Subject: 2023/93031 - Wappy Springs Inn, Lindley Moor Road, Lindley Moor, Huddersfield, HD3 3TD.

Lisa Reardon
Designing out Crime Officer
Wakefield District

Scale	Size	Date	Drawn	Checked
1:500	A3	DEC'22	MH	.
Status	<b>PLANNING</b>			
KPP Job No <b>2278</b>	Rev <b>A</b>	Number <b>2002</b>

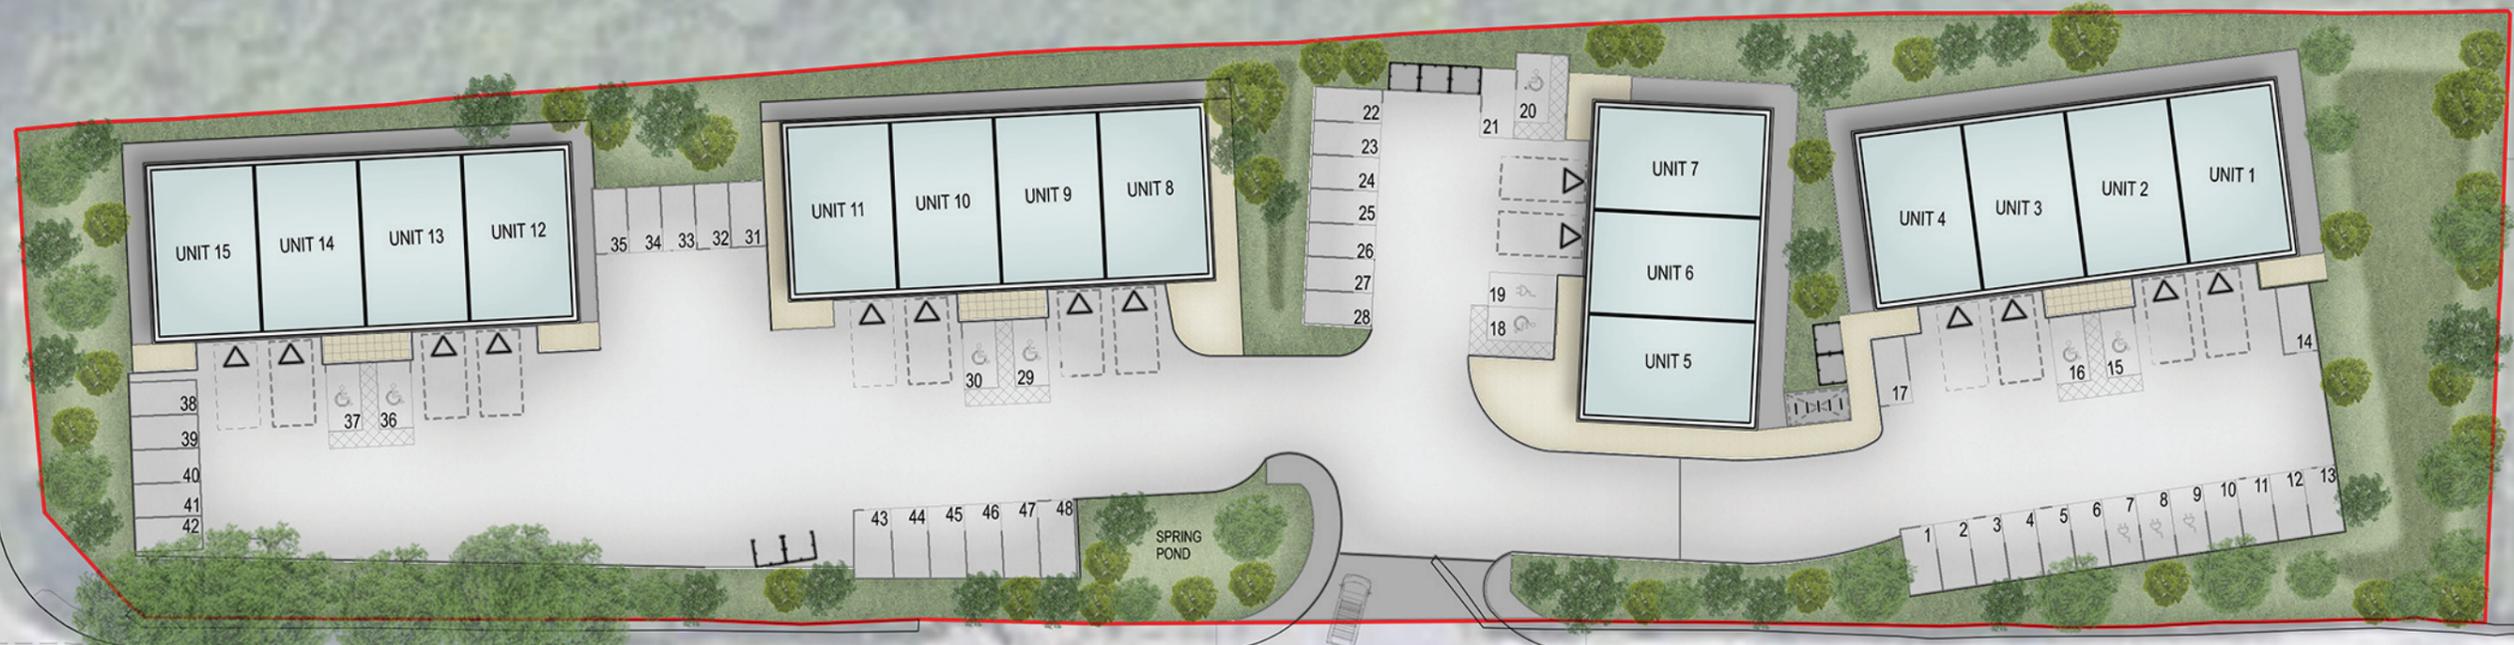
We would recommend that there be secure boundary treatment around the perimeter of the site to increase security for the units. Fencing should be to a minimum height of 2.2m, such as closed welded mesh fencing to standards LPS 1175 SR2, B3, which would increase security and allows good natural surveillance into the site.

There is no mention of the site plan of any gated access to secure the site outside of business hours. The concern with open access is that any stranger or potential offender can enter the car park, there is also potential for ASB problems within the car park in an open site. We would recommend that there be either automated sliding gate, which secures access into the site or as an alternative a manual operated gate to the same height, material, and standards as the fencing, which allows the site to be secured outside of business hours and reduces the risk of crime and ASB problems.

We would recommend installing monitored CCTV that covers the site entrance / egress, car park, bicycle storage and front of the unit's entrance doors, which increase surveillance around the site. CCTV should be high-definition cameras to 1080p, which are of a quality that can identify person/s from the top half of their body, or clearly identify a vehicle registration number, make and colour of a vehicle. If cameras are monitored, then any issues, problems can be immediately identified and actioned. Whereas CCTV that automatically records and retains images for a period and overwrites, only tends to be checked or reviewed when an incident has happened, however if the last option is only available, this would be preferable as opposed to having no CCTV coverage.
